Development Facilitation Team (DFT) – Review Comments

DRB Project No: PR-2020-004622 Date: 04/05/2023 Agenda Item: #3 Zone Atlas Page: L-15

Location: 1401 GIBSON BLVD SE

Application For: SI-2023-00592-SITE PLAN ADMINISTRATIVE (DFT)

**LANDSCAPE PLAN**

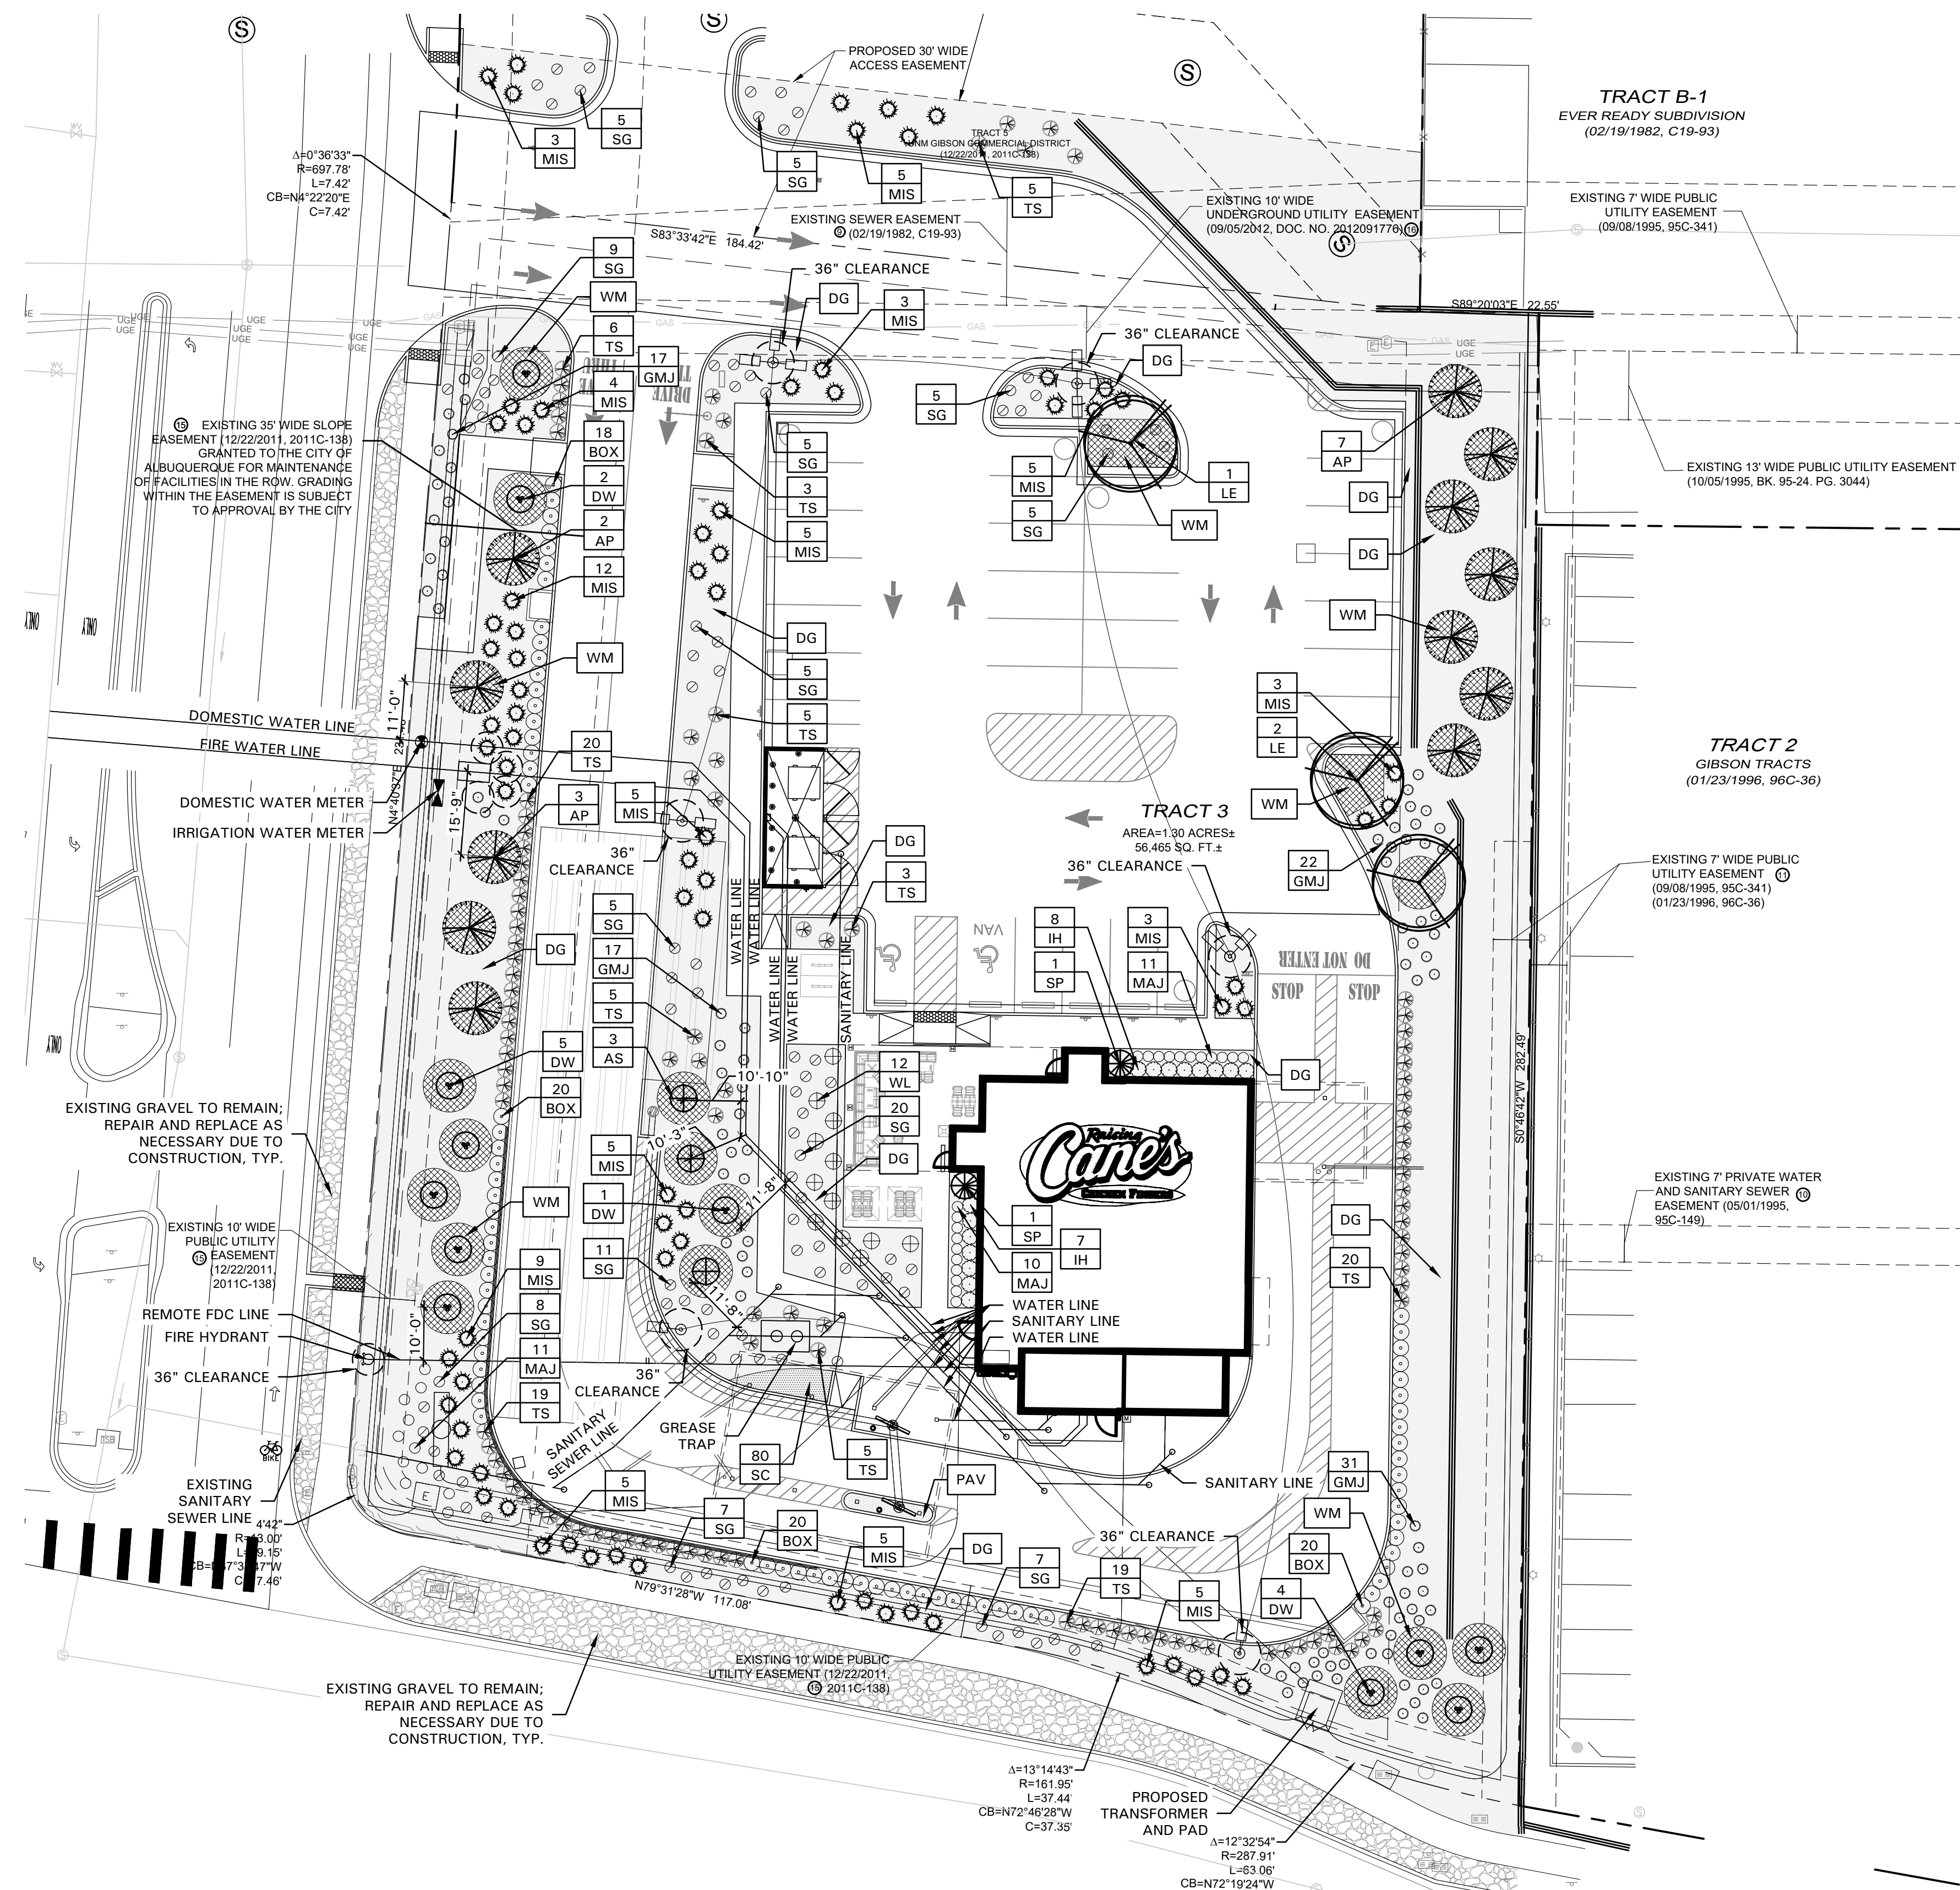
Street Trees are generally required every 25' on center along street frontage within 20' from back of curb. The site plan shows groupings of 3 trees farther apart than 25 feet. If 25' spacing cannot be met due to site constraints or desired landscape, please explain and/or clarify on plans why the spacing cannot be met.
